Planning Application Reference No.: 3/2026/0488

Address of Development: Land to the rear of The Nook Snodworth Road Langho BB6 8DR

RE: Planning Application Objection – REF 3/2026/0488

Proposed Development: Construction of 6 residential dwellings with landscaping.

SURFACE WATER DRAINAGE STRATEGY

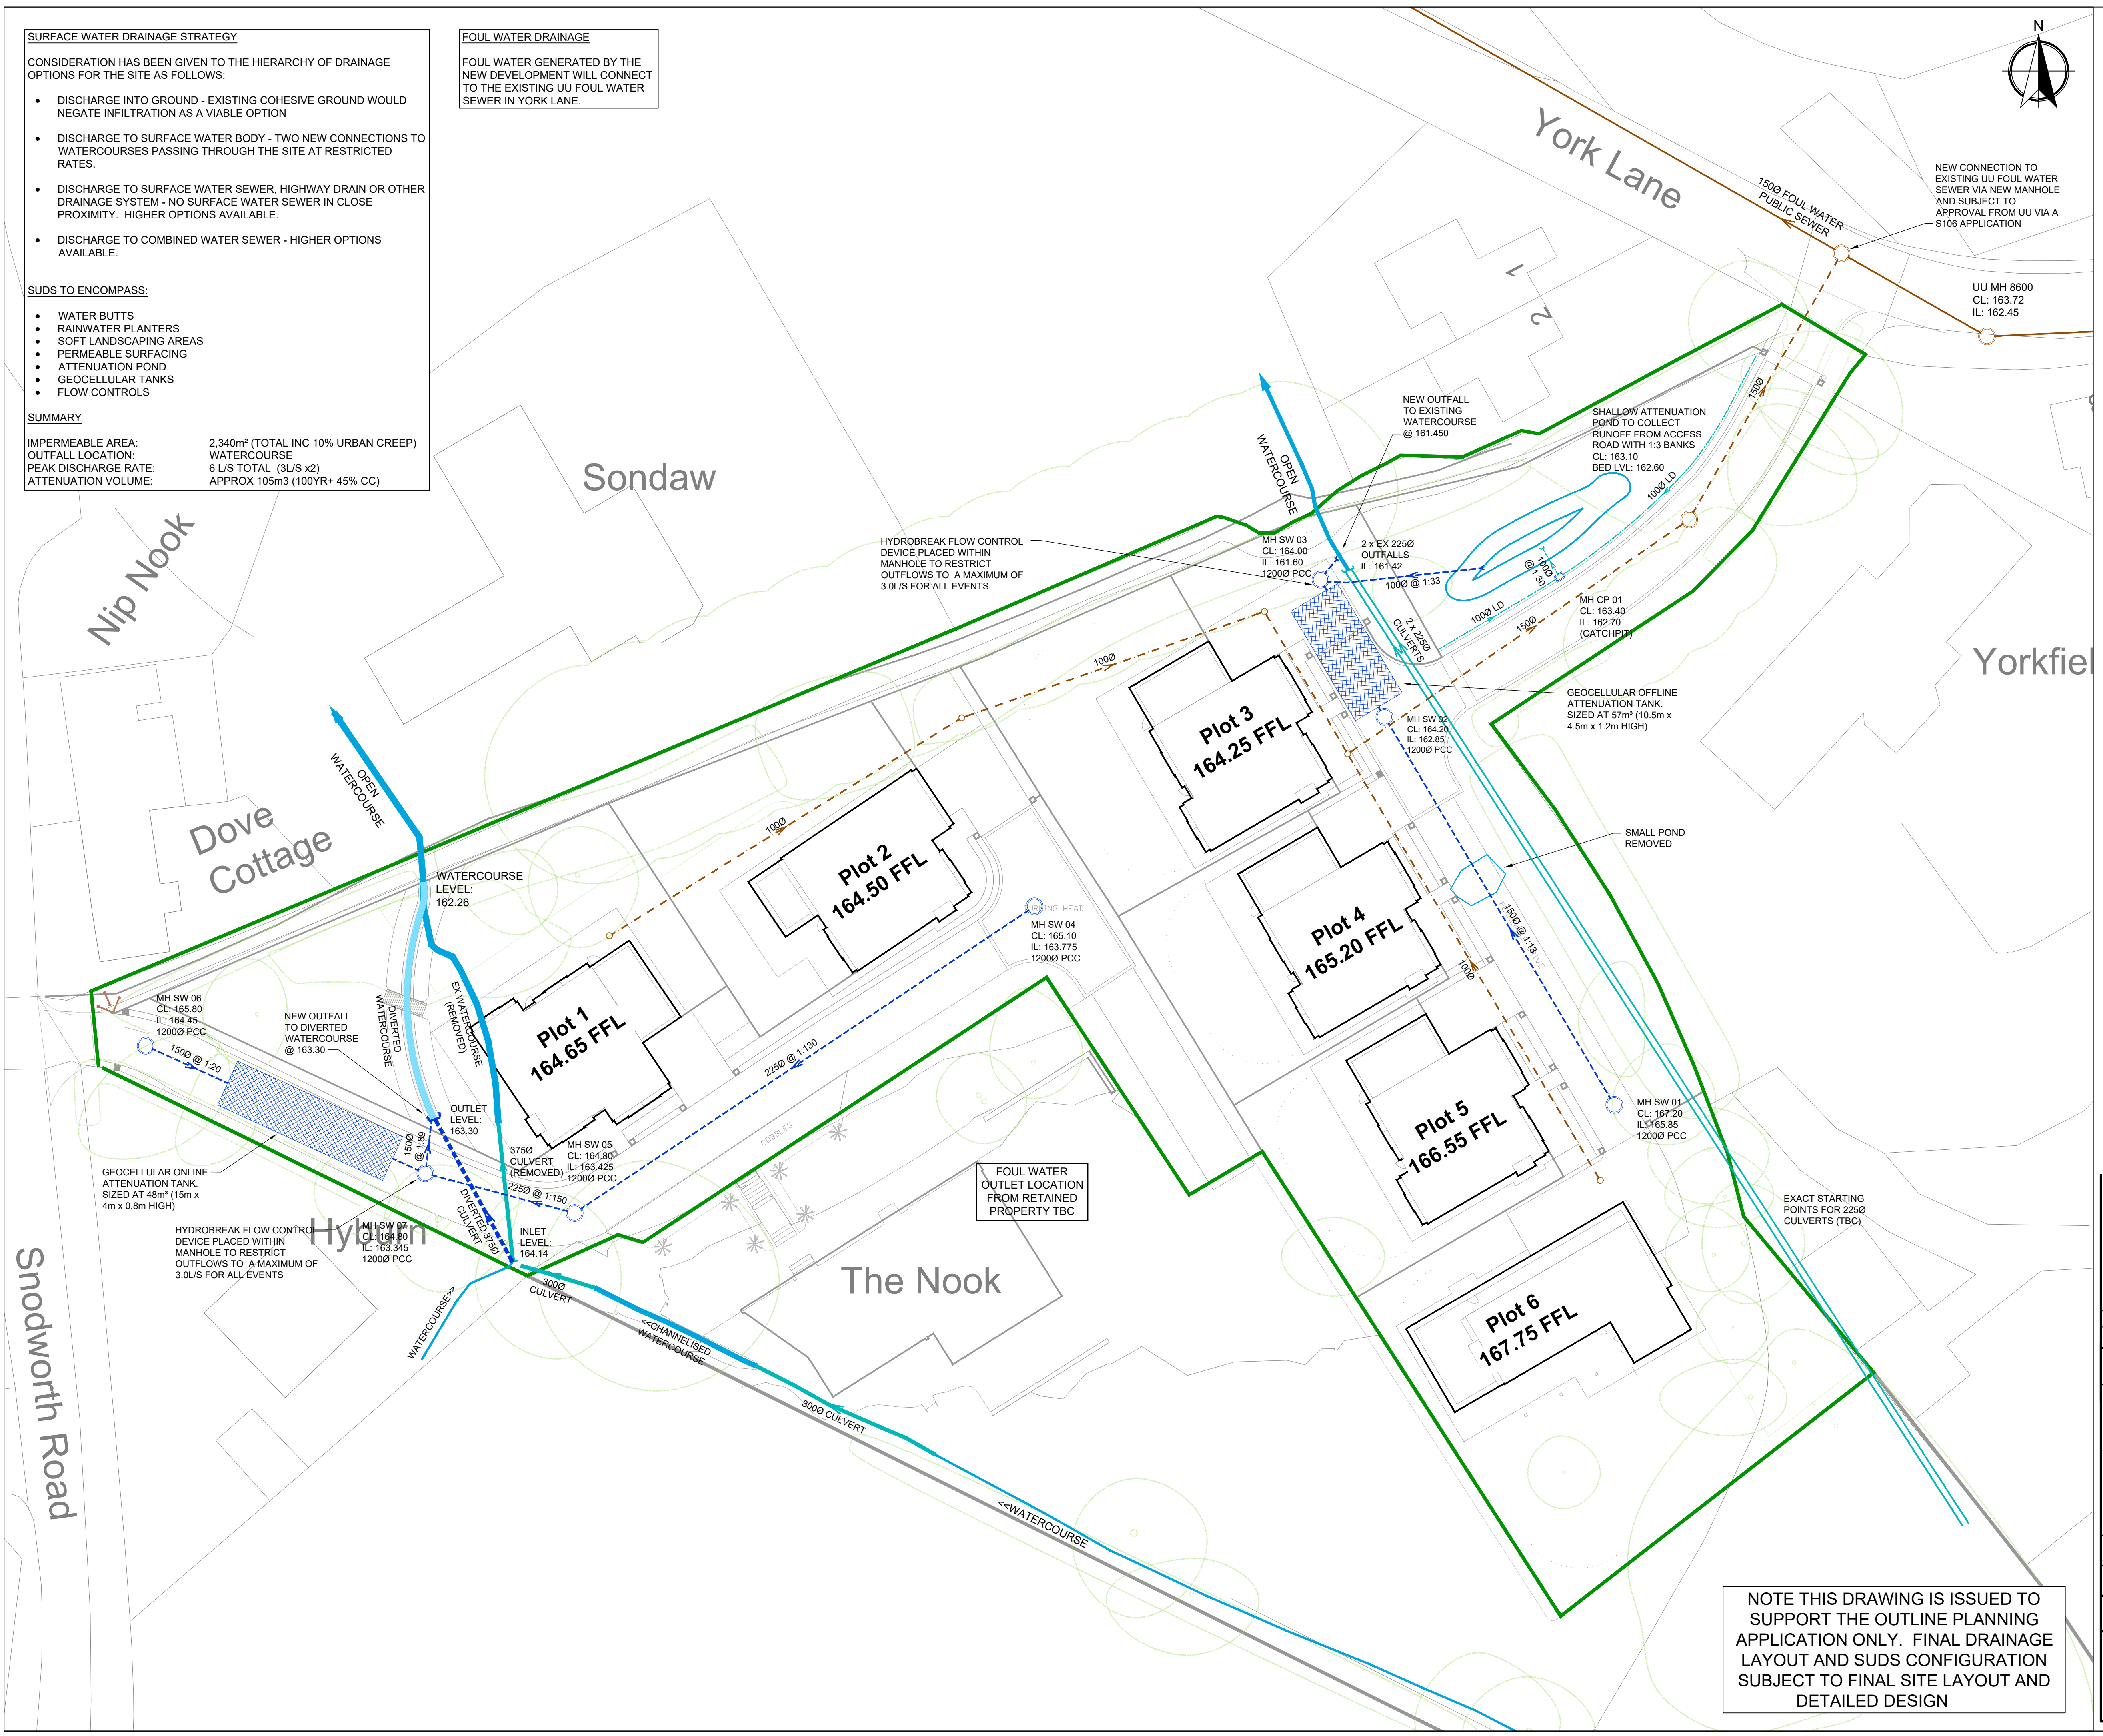
[REDACTED] There is also a stream which flows down the left side of the property onto Sondaw's land. In the application the 'no' box is selected under the Assessment of flood risk section which asks 'is the proposal within 20 meters of a watercourse?' The answer should be 'yes'. The pond for example, is of a significant size (at one point it accommodated a rowing boat). Where will this water go? I note that there is a small stream created as a 'feature' on Plot 1, this will not accommodate the run-off.

Figure 1 – Crashmap Screenshot – Snodworth Road/York Lane

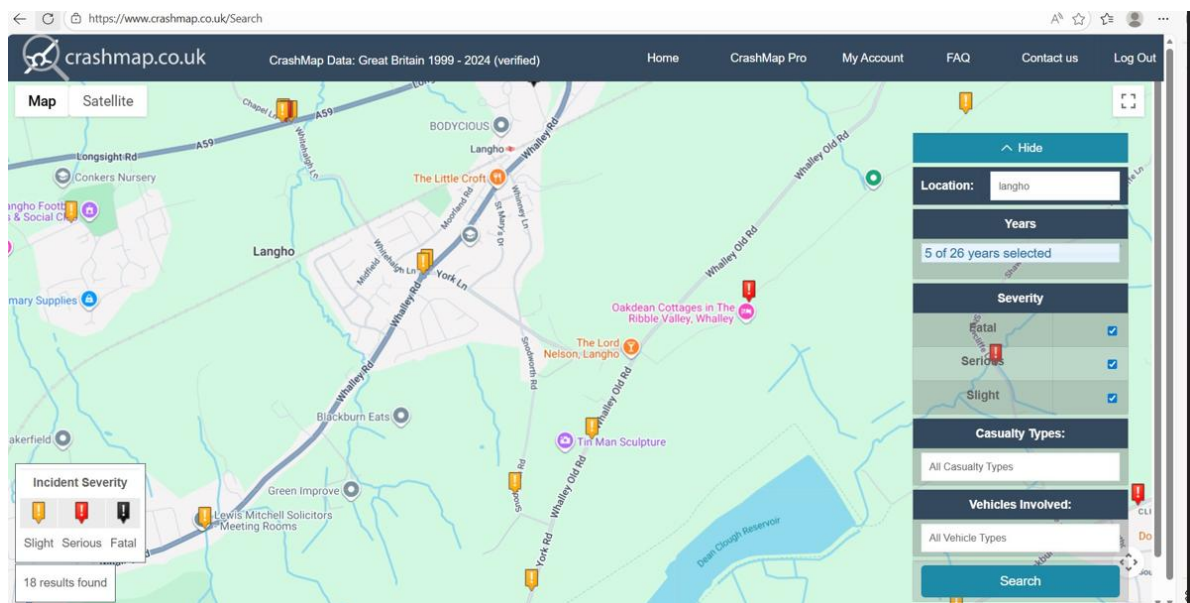
This application refers to data from crashmap.co.uk which shows Snodworth Road and York Lane as 'safe roads'. This is incorrect, given the number of motor accidents that have occurred on Snodworth Road alone, so this data is unreliable.

On a final note regarding road safety, the application states that there are no reported accidents.

This again questions the integrity of the application and data used.

Z:\projects\4889 York Road, Langho\CAD\EDDISONS DRAWINGS\4889-F02 Rev B (Proposed Site Access).dwg

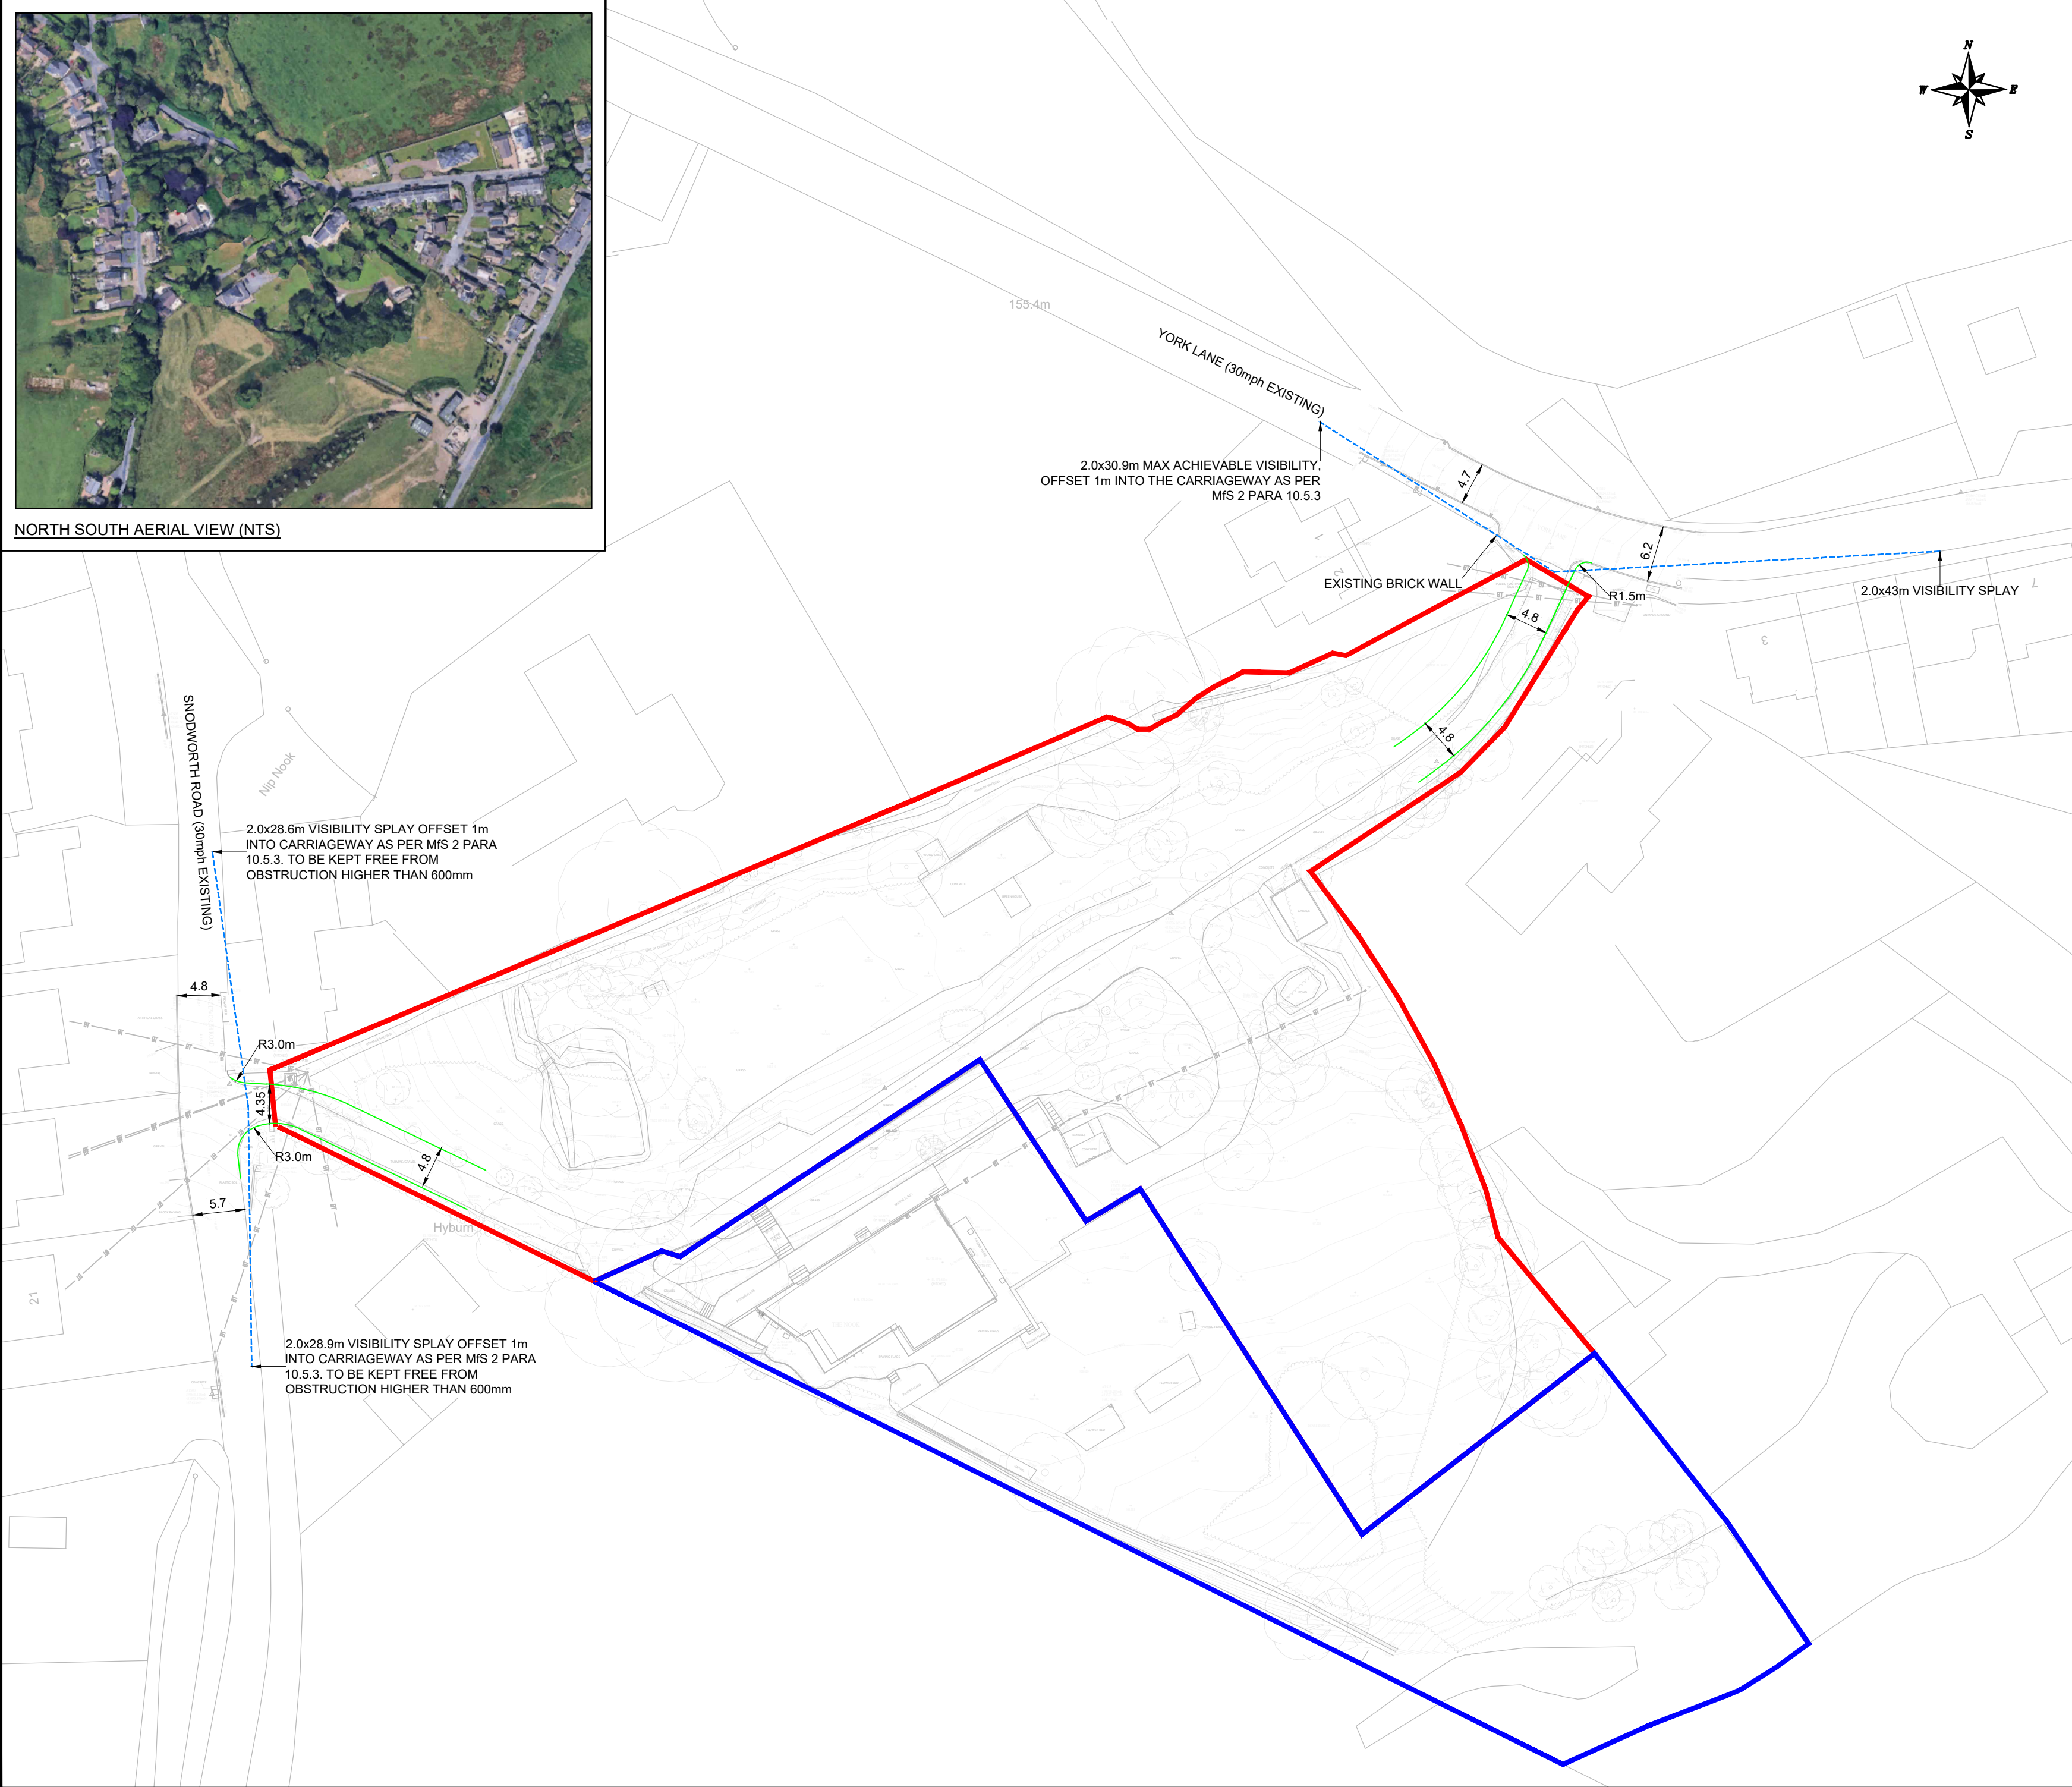
The visual splay for upcoming traffic on Snodworth rd, on the same side is virtually none existent.

York Lane is not good either and under modern legislation this would not comply, both are not wide enough for two cars to pass.

The Nook's access drive from Snodworth Road is narrow and will only accommodate a single car and not a two-way flow of traffic. This will cause stationary traffic on a blind bend. The vision splay from The Nook onto Snodworth Road is also inadequate.
